Date 27 June 2019

RE: 6/2019/0085/MAJ – Chancellors School, Pine Grove, Brookmans Park, Hatfield, AL9 7BN

Julia Puton
SuDS Officer
Hertfordshire County Council

Drawing Title
 SURFACE WATER DRAINAGE STRATEGY
 EXISTING AND PROPOSED
 IMPERMEABLE AREAS

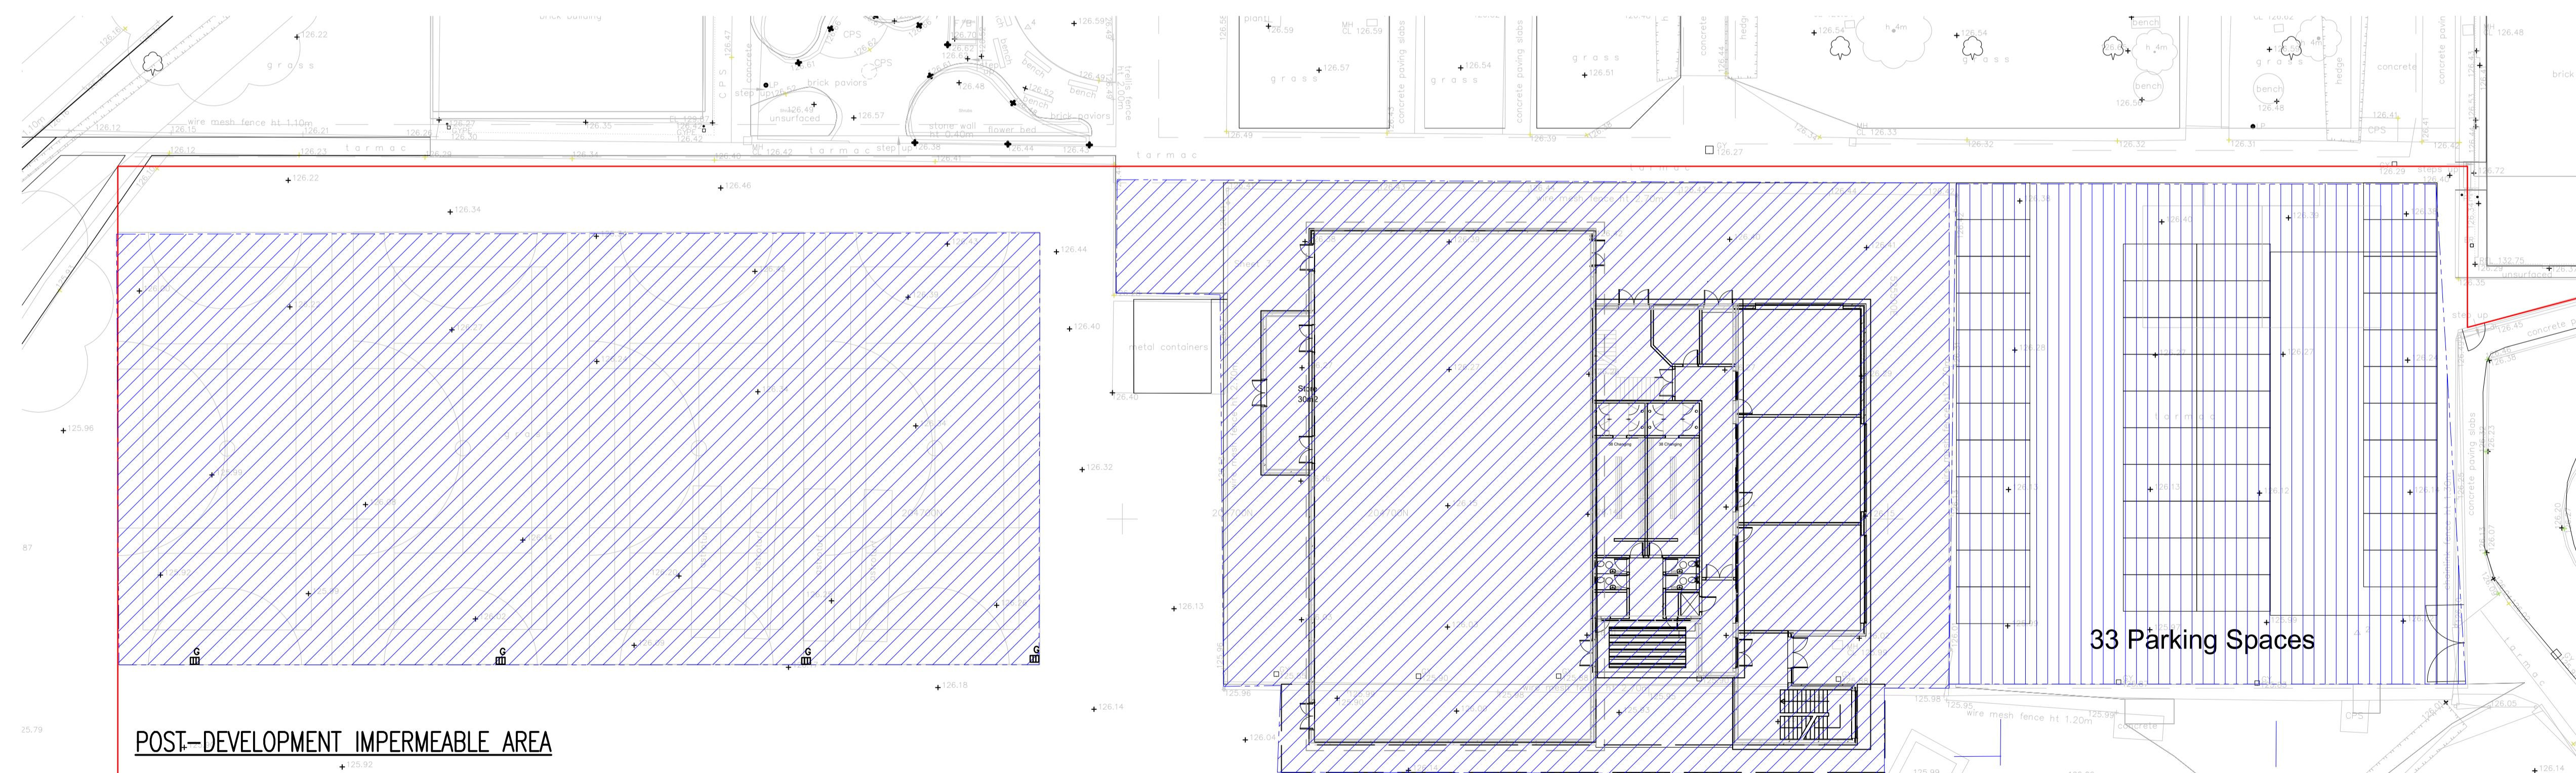
Following a review of the Flood Risk Assessment and Drainage Strategy prepared by Ingent Consulting Engineers, dated March 2019, the updated Surface Water Drainage Strategy Drainage Arrangement prepared by Ingent Consulting Engineers, drawing number 1903-330_001, revision A, dated 26 April 2019 and additional information sent to the LPA, we can confirm that we, Hertfordshire County Council as the Lead Local Flood Authority are now in a position to remove our objection on flood risk grounds.

The drainage strategy is based upon filter drain, cellular storage tanks and discharge into the existing connection into Thames Water surface water sewer. We note surface water calculations have been updated and ensure that the drainage strategy caters for all rainfall events up to and including 1 in 100 plus 40% for climate change with 5 l/s discharge to surface water sewer.

Surface Water Drainage Strategy Drainage Arrangements drawing, drawing number 1903-330_001, revision A, dated 26th April 2019 and the following mitigation measures detailed within the FRA:

1. Limiting the surface water run-off generated by the critical storm events so that it will not exceed the surface water run-off rate of 5 l/s during the 1 in 100 year event plus 40% of climate change event.
2. Providing storage to ensure no increase in surface water run-off volumes for all rainfall events up to and including the 1 in 100 year + climate change event providing a minimum of 168 m³ (or such storage volume agreed with the LLFA) of total storage volume in cellular storage tanks.
3. Discharge of surface water from the private drain into the Thames Water surface water sewer network.
